Our Case Number: ACP-323849-25

An
Coimisiún
Pleanála

Re: The proposed development is for a mixed use development that seeks the regeneration and adaptive reuse of a strategic brownfield site, as part of the Limerick City and County Council 'World Class Waterfront revitalisation and transformation project' 'Cleeves Riverside Quarter' in the townland of Farranshone More in Limerick City.

RE. CLEVES Riverside Development.
CASE NO 323849-25.

drawing Stonetown Terrace Sections

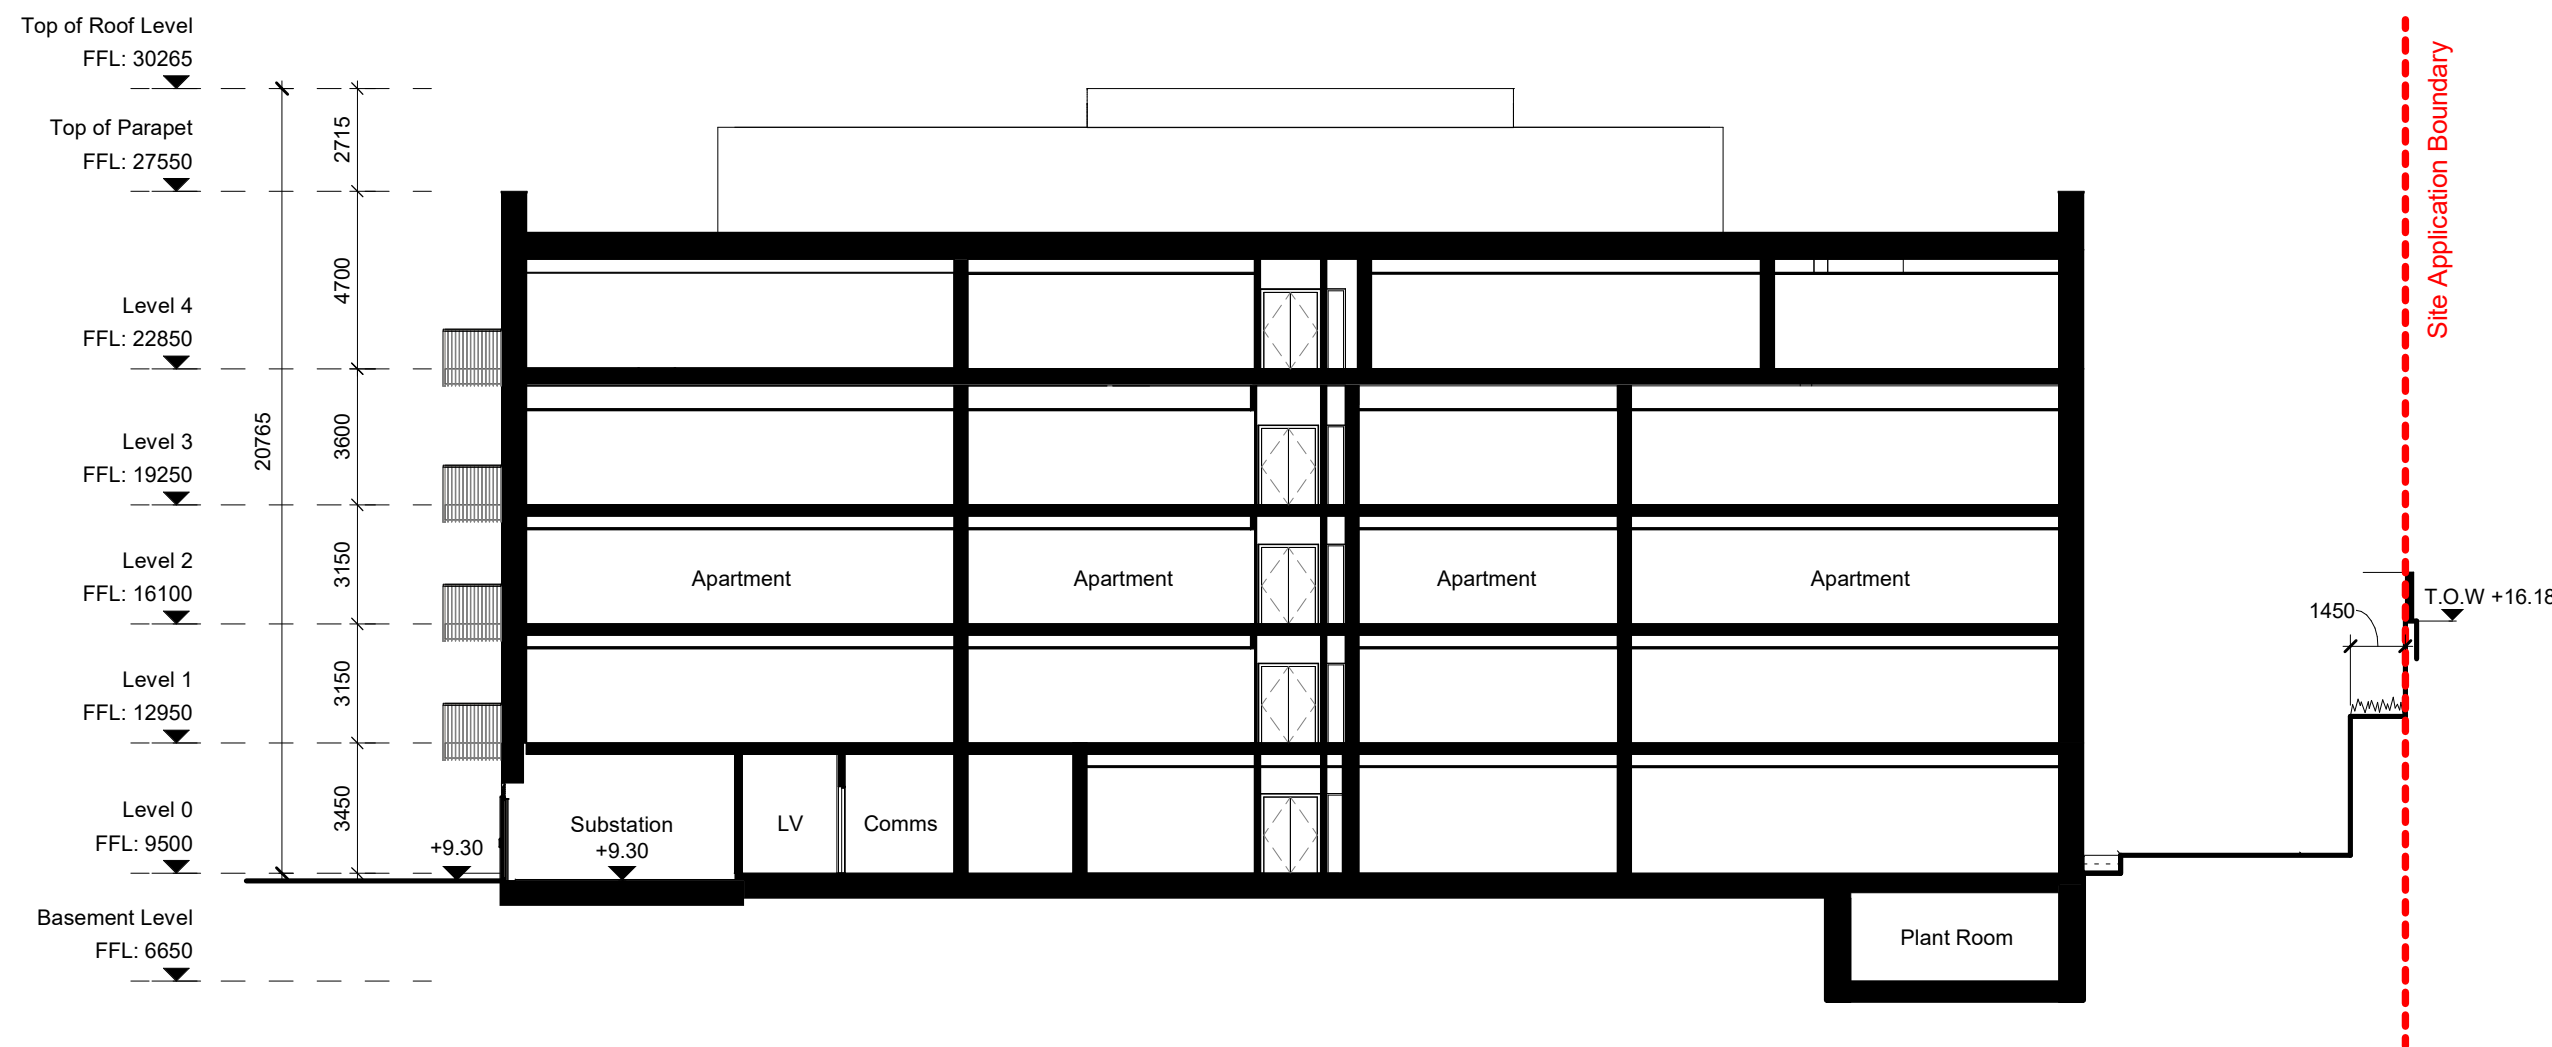
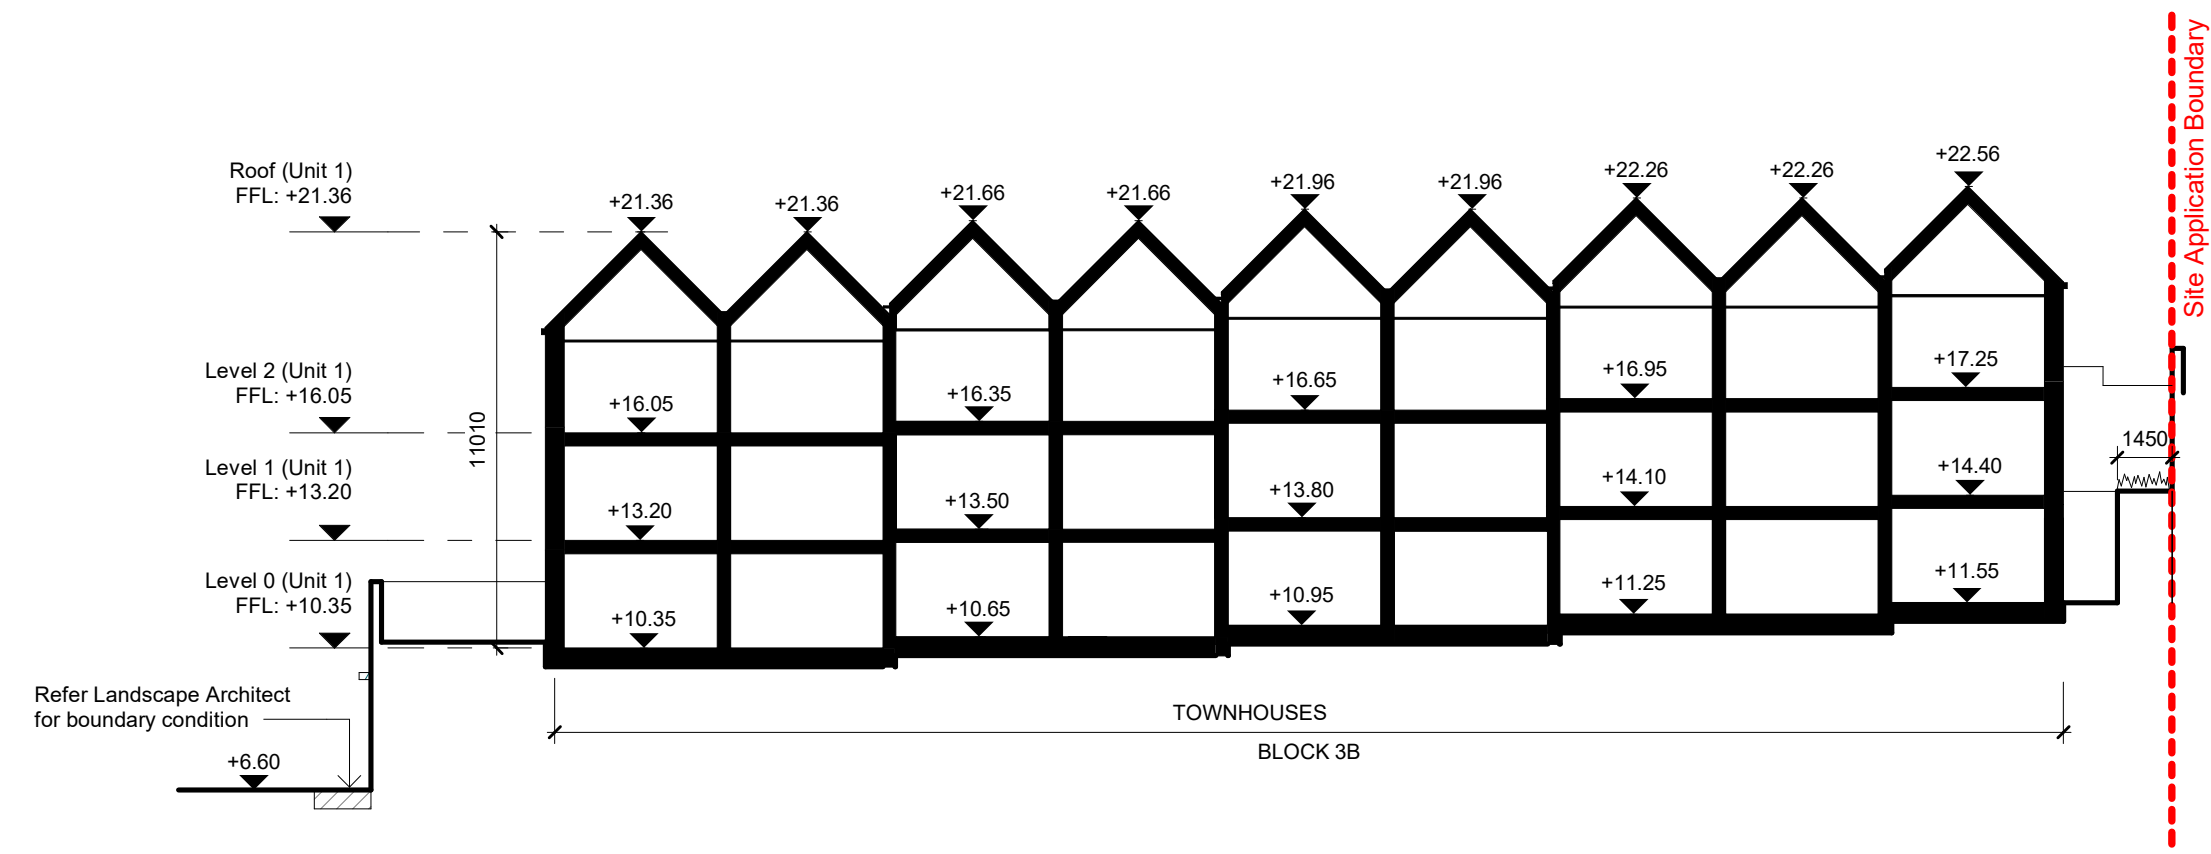
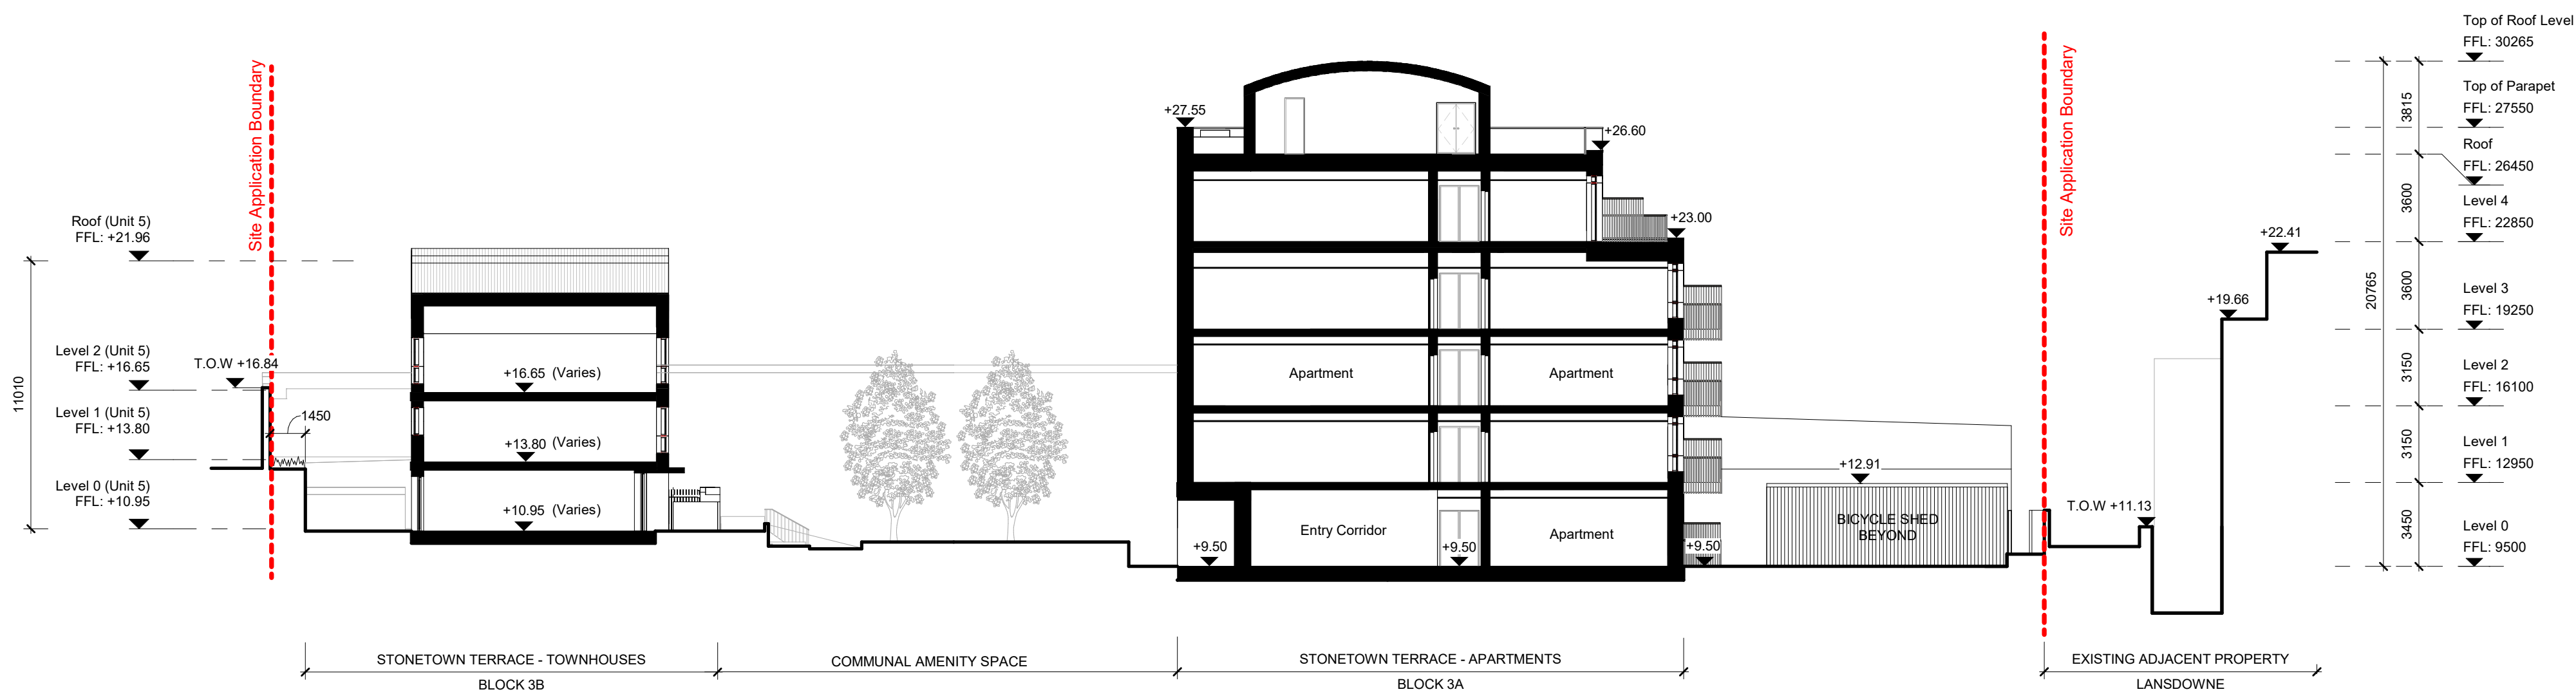
There will be a significant loss of sunlight and privacy for the residents of Stone Town TCE due to the height of the proposed buildings on the road. It will result in over shadowing and reduce the quality of life particularly for those with gardens. It will also reduce privacy due to balconies and windows of the proposed building overlooking the houses. There also appears to be a plan to use Stone Town TCE for HSB substations Telecoms room and commercial rubbish for the apartment block looking onto Stone Town TCE.
